App No: CM/20/18/PL

Address: Clymping Mill Clymping Street Clymping BN17 5RN

Proposal: Erection of security fencing. This application may affect the setting of a listed building.

**Liz Rogers**
Environment Officer
Environment
Chichester District Council

**Figure No. 01 - Site Habitat Plan
Climping Mill, Climping**

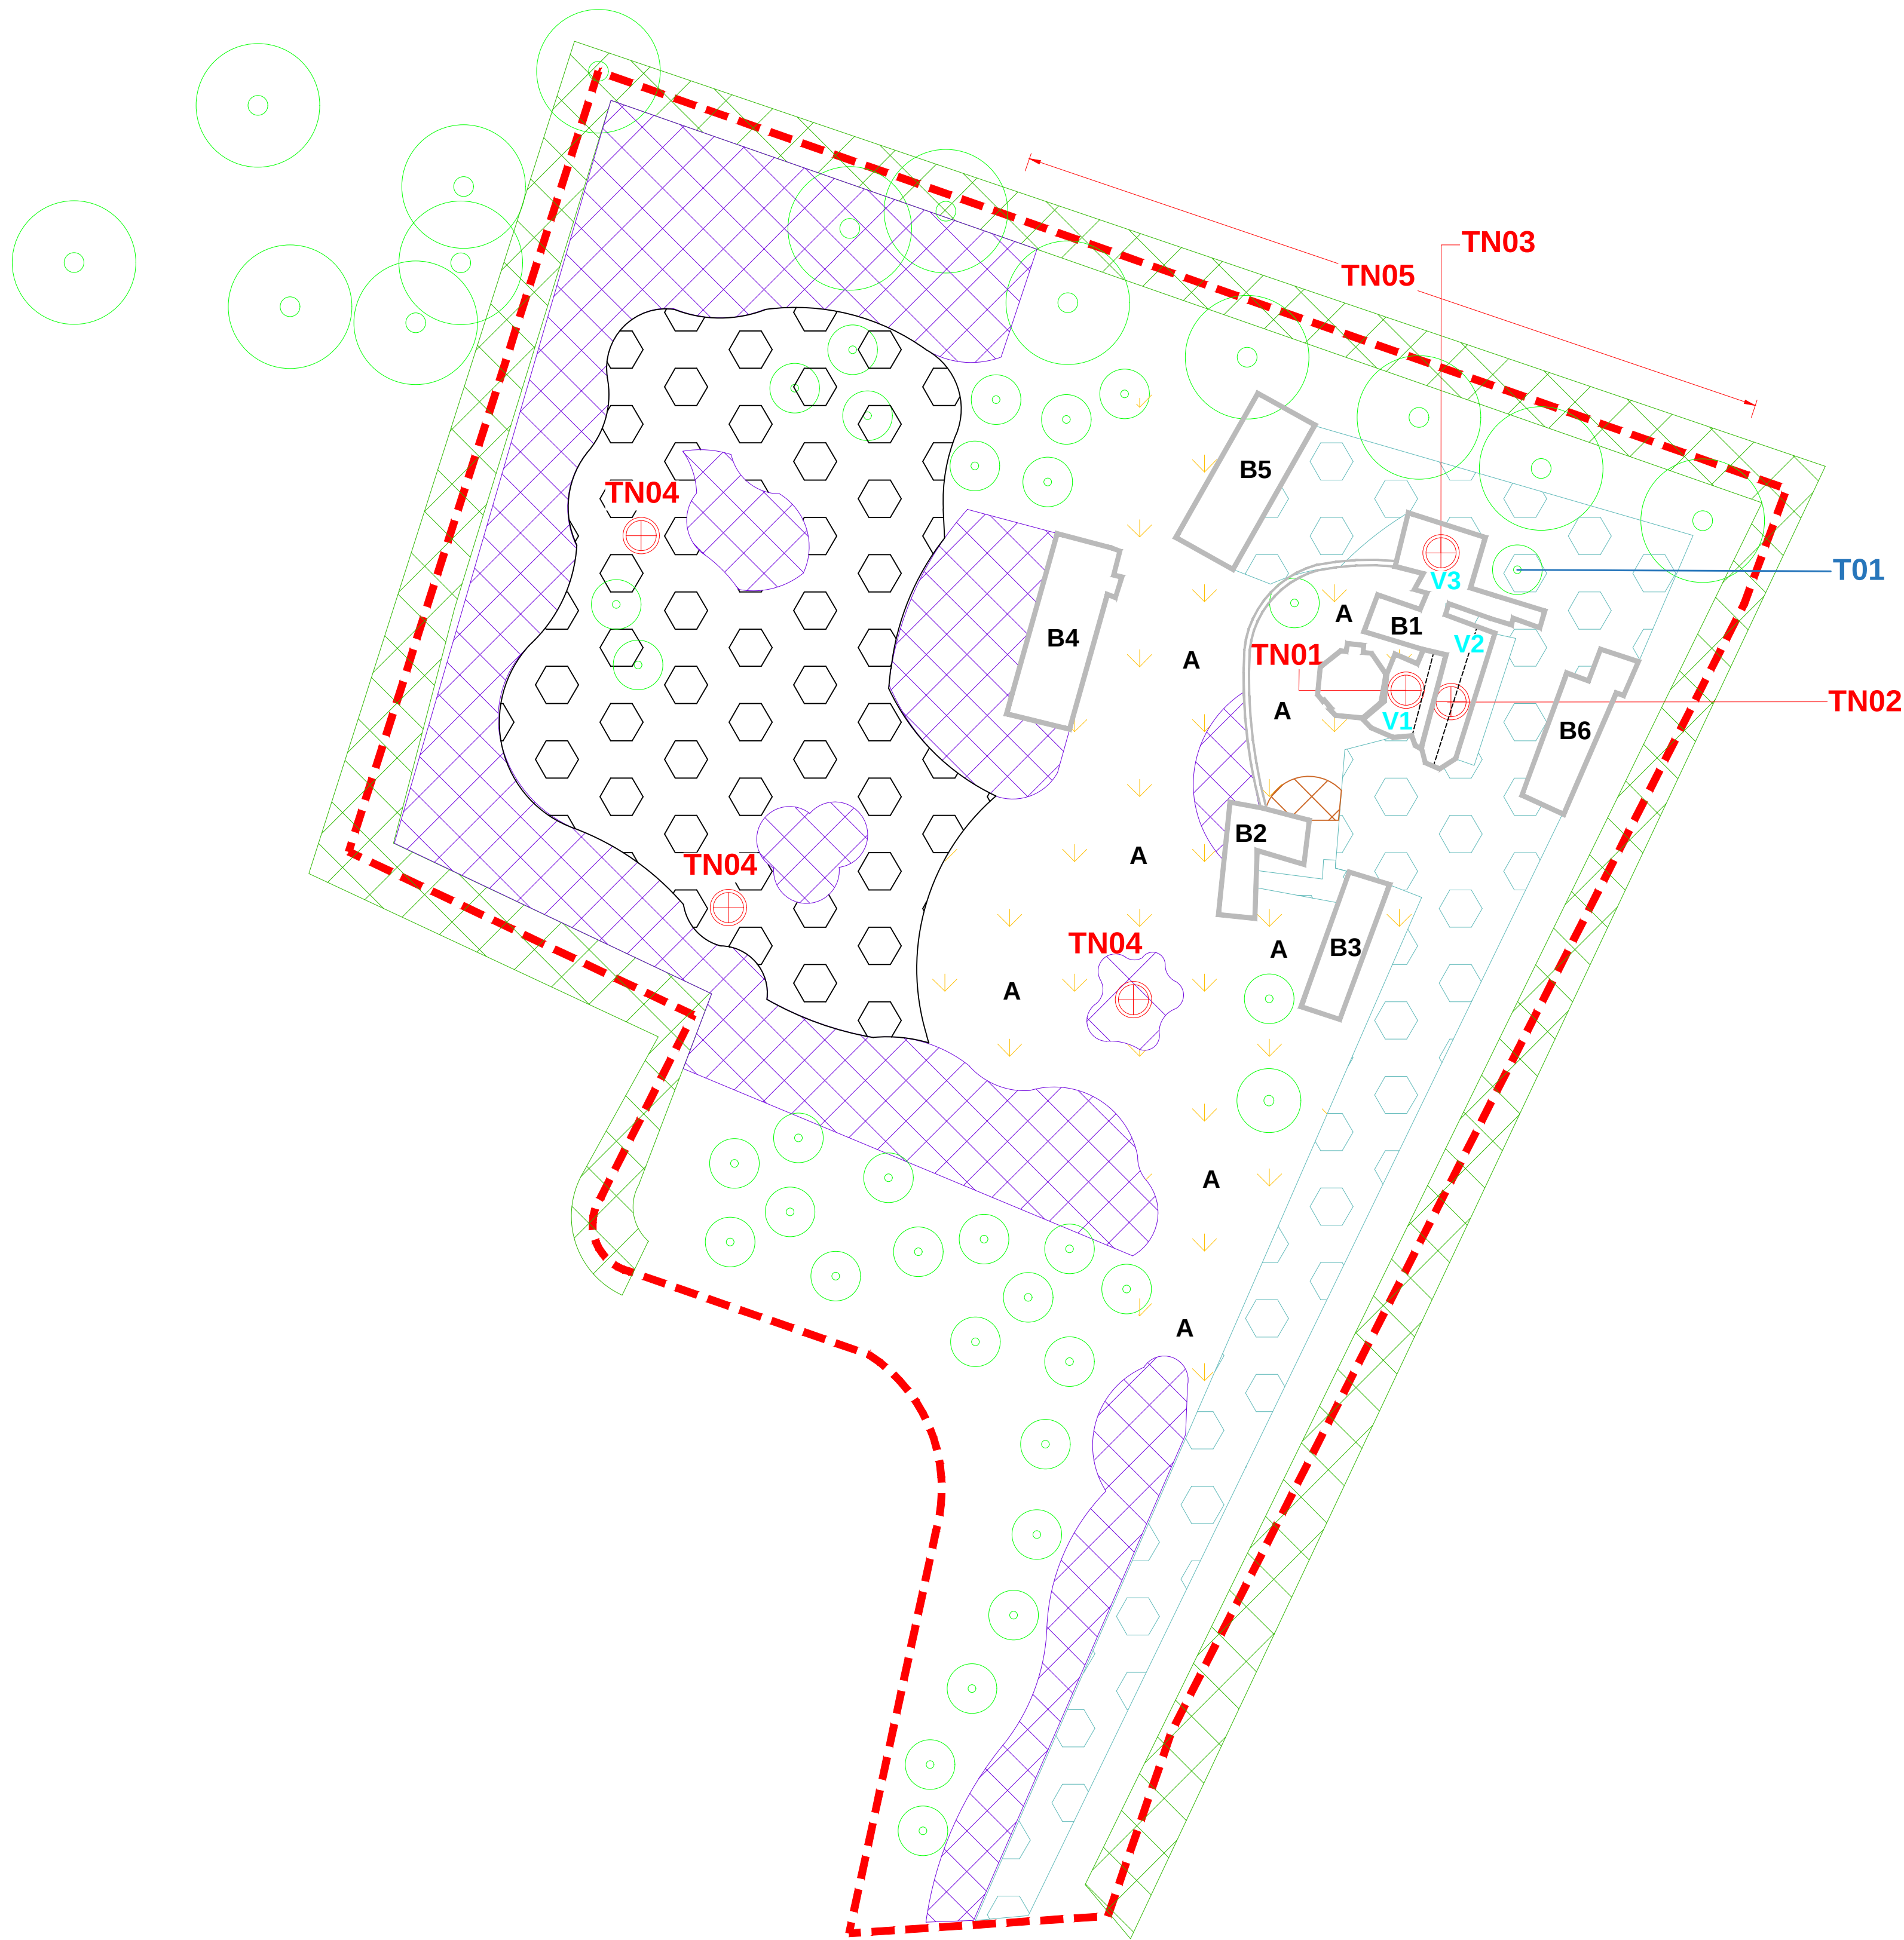
Within the design and access statement it states that no vegetation would be removed for the installation of the fencing, if this is not possible and hedgerow needs to be removed, further investigation would be required for the works to assess the impact on protected species including bats and dormice.

As detailed above within the design and access statement it states that no vegetation would be removed for the installation of the fencing, if this is not possible and vegetation needs to be removed, it is likely that reptile habitat would be impacted upon by the works, and further reptile activity surveys would be required.

To ensure movement of local wildlife is not restricted by the fencing, wildlife friendly fencing should be used onsite so wildlife (e.g. badgers) can still move freely across the site.

Any works to the trees or vegetation clearance on the site should only be undertaken outside of the bird breeding season which takes place between 1st March – 1st October. If works are required within this time an ecologist will need to check the site before any works take place (with 24 hours of any work).
